13th March 2019

RE: Planning Application NO. 2019/62/90501/E Erection of double garage

Ordnance Survey Plan

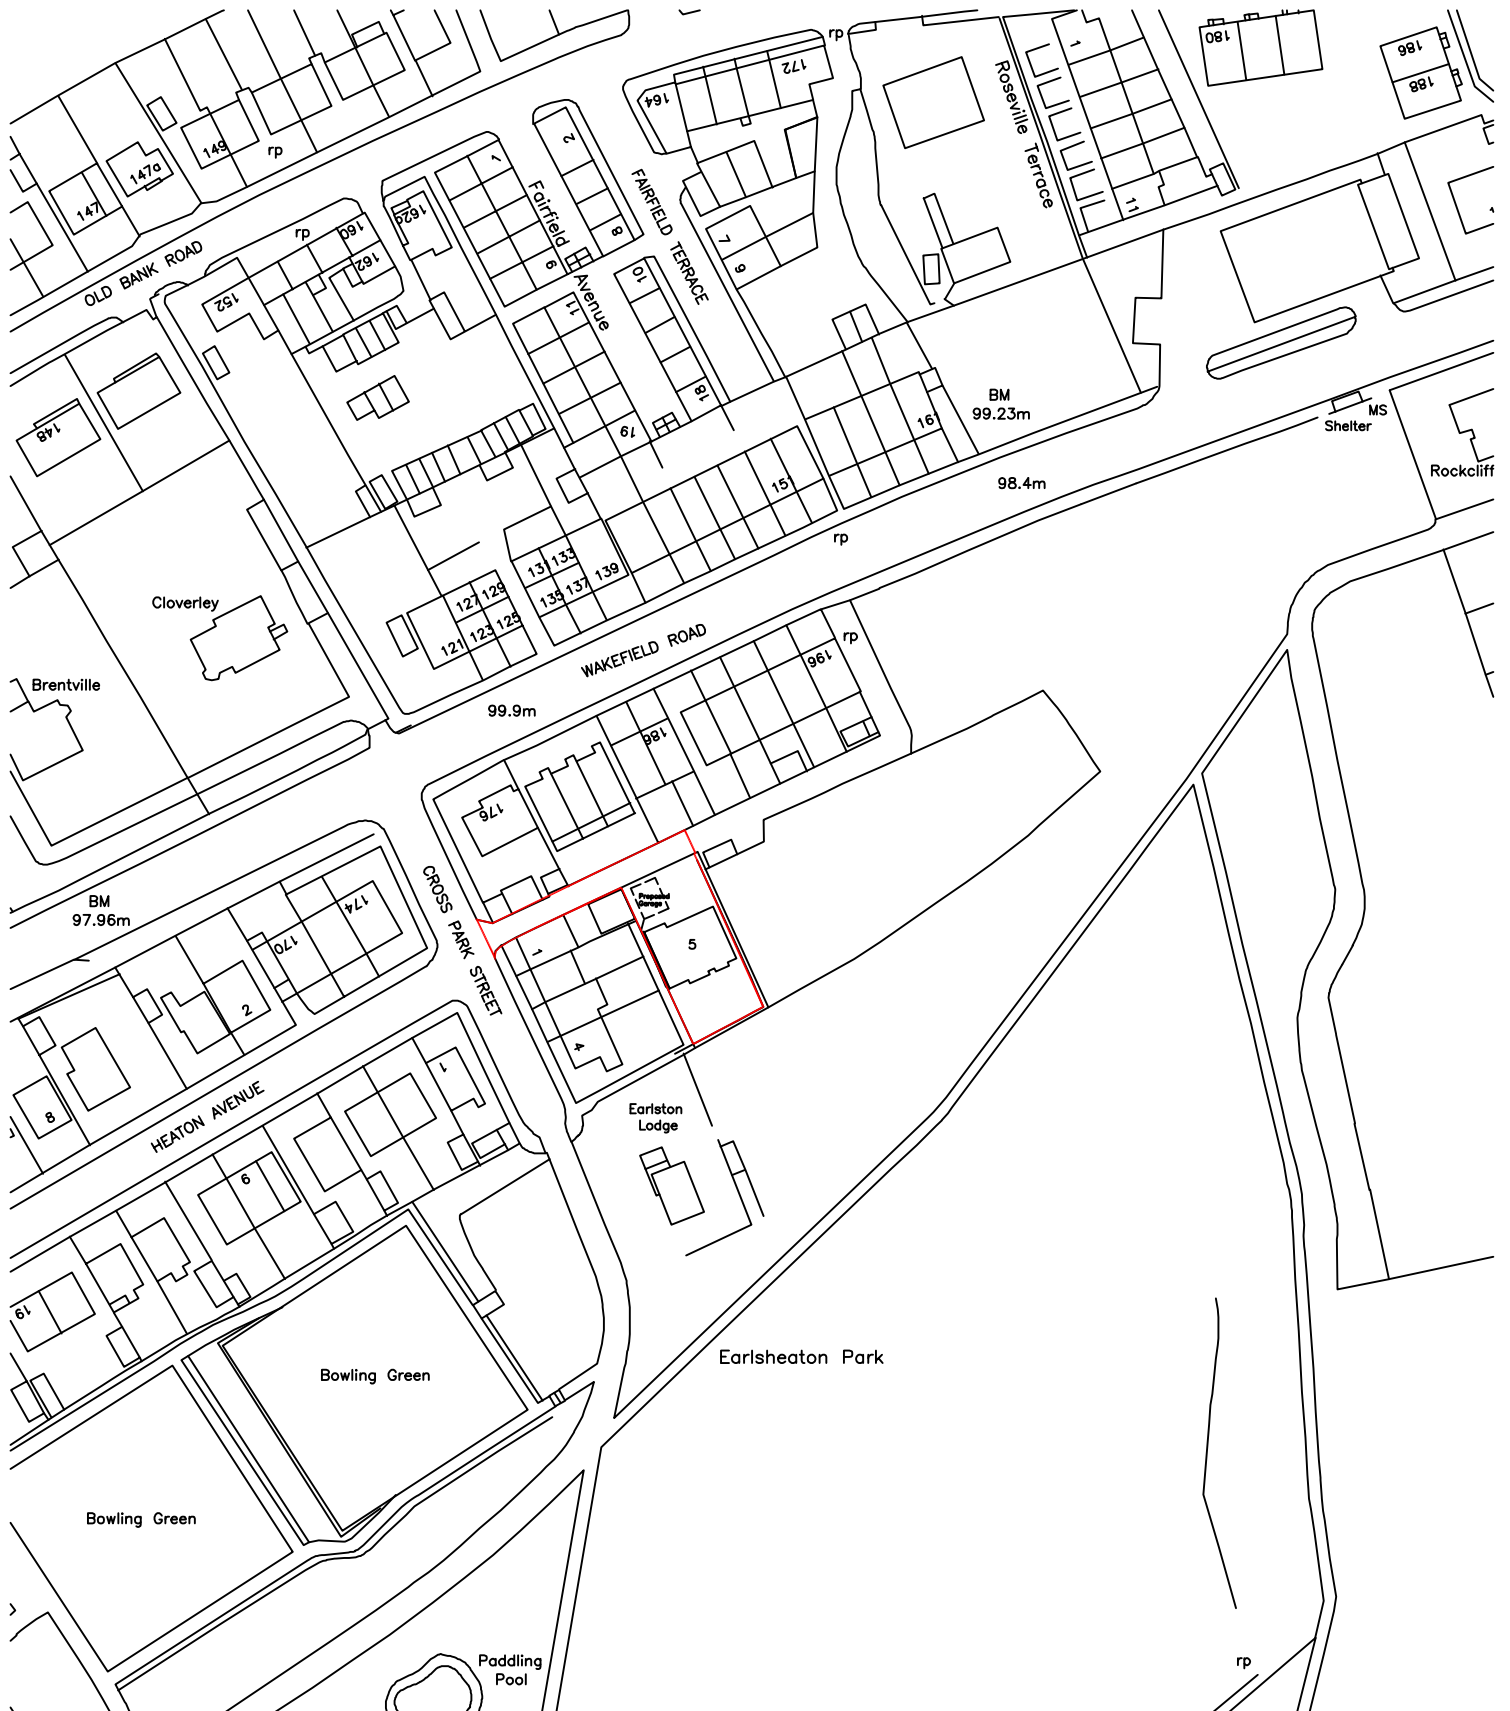
We believe that the proposed site is a direct contravention of this policy. The access to the site remains substandard in terms of construction, including potholes with a number of refuse bins lining the path to serve residents of Wakefield Road. There is also a lack of footways,

and turning provision for service vehicles, with narrow access such that two vehicles could not pass. The access road already serves a number of garages and parking areas to the rear of the houses on Wakefield Road and it is considered that a further increase in use would be detrimental to the safety and visibility of the current residents of Wakefield Road.

Furthermore, we would also like to draw your attention to the fact that the back road leading to the proposed site is 12 feet wide. '

In addition to our objection, we are aware that the current garage on the proposed development site was erected to serve the property of No.4 Cross Park Street yet planning permission on the same site to erect the double garage has been applied for under No. 5 Cross Park Street, which is causing some confusion to as to what land the existing garage belongs to and if this indeed a legal application?
